**From:** Nicola Spencer on behalf of Planning.Responses  
**Sent:** 11 December 2025 15:53  
**To:** Planning Scanning  
**Subject:** FW: PLEASE ADD TO MY PLANNING OBJECTION SEEE 45 DEGREE RULE TO ADD

Application No: R/215/25/HH

Dear Sir/Madam,  
Town & Country Planning Act 1990 (as amended)  
Town & Country Planning (Development Management Procedure) (England) Order 2015  
Application No: R/215/25/HH  
Site Address: 21 Sutton Avenue Rustington BN16 2ES  
Description of works: Single storey rear extension.

Drawing:  
**Plans and elevations as proposed**

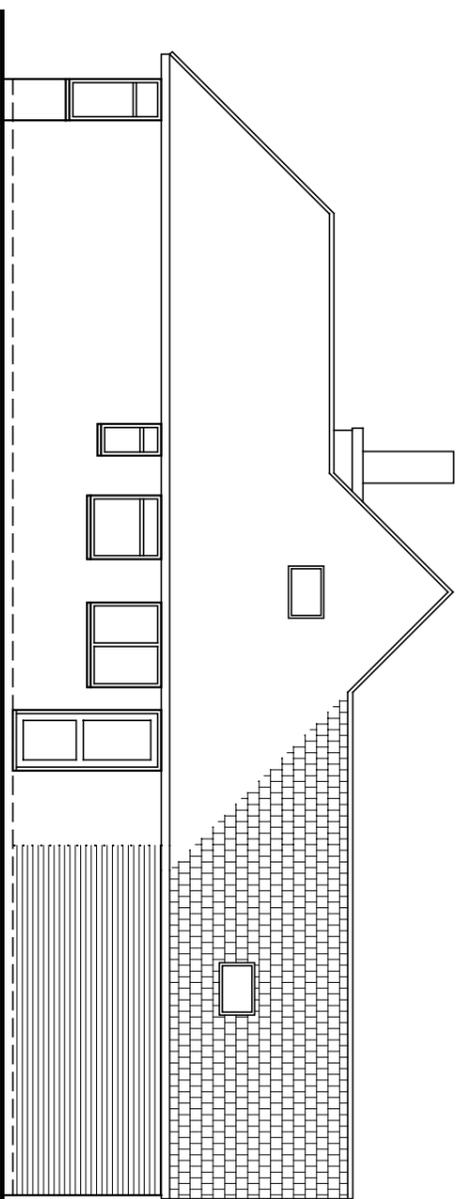
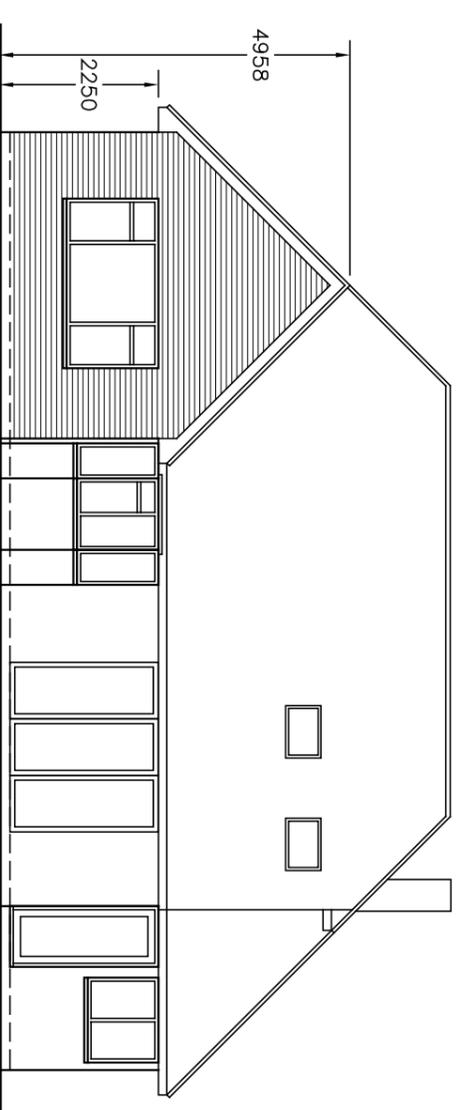
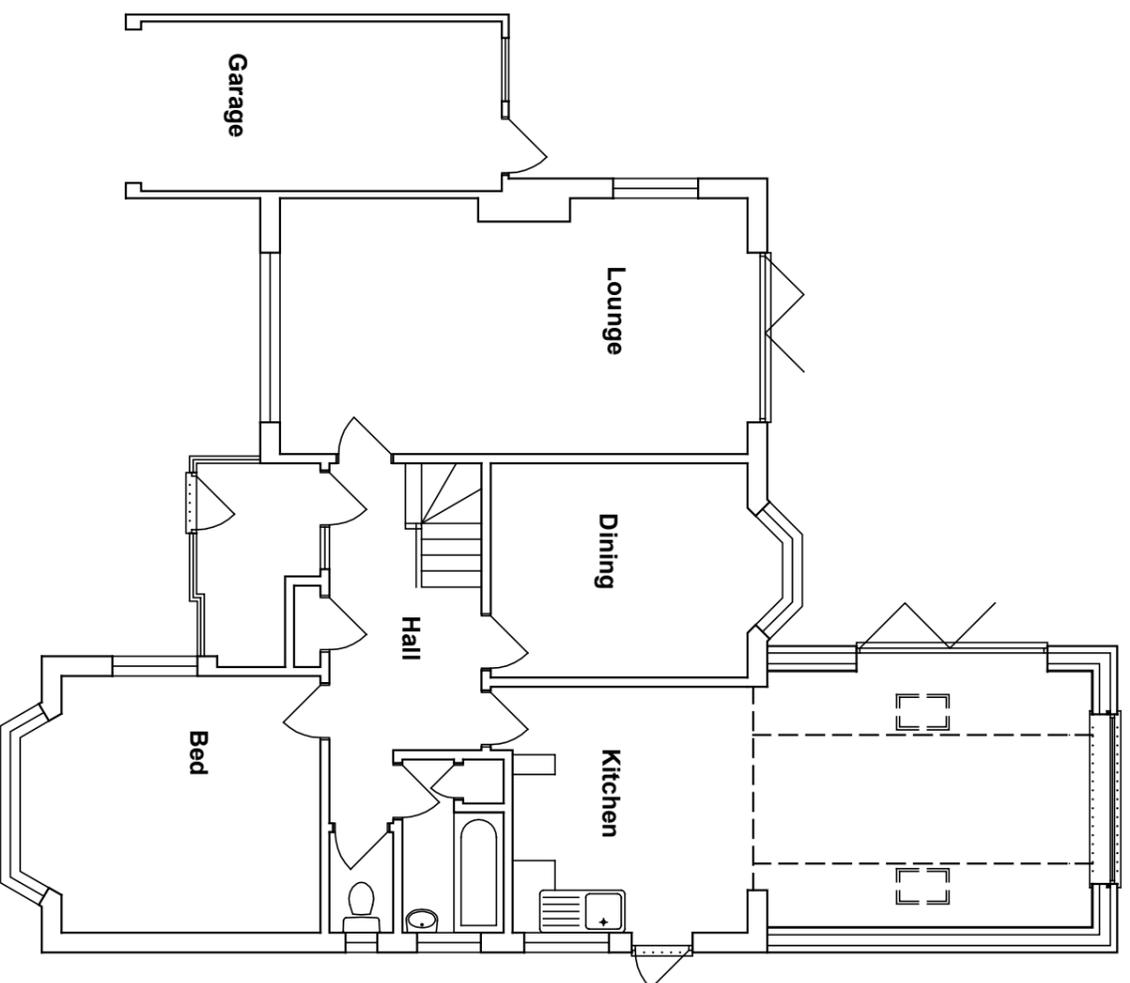
I have reviewed the extension plans submitted to Arun DC, in relation to your information and the available aerial photography. I can see that there is likely to be some loss of light to your property at 1 Evelyn Avenue, in particular, to the rear conservatory, which I understand serves your lounge.

THOMPSONS EXTENSION ON " MY SOUTH SIDE BORDER FALLS WITHIN A "45 DEGREE RULE" ANGLE TAKING MY CLOSEST WINDOW,  
,LIVING ROOM ,CENTRE OF WINDOW

HAS BEEN MEASURED FROM CENTER OF MAIN LIVING ROOM WINDOW WHICH IS CLOSEST TO THEIR P[LAN]S EXT.

Thompson family are trying to build within "45 degree angle" you will see on their plans,which will block light, heat push us both into dark ,see centre of main living room window and

their plans for extension fall in angle
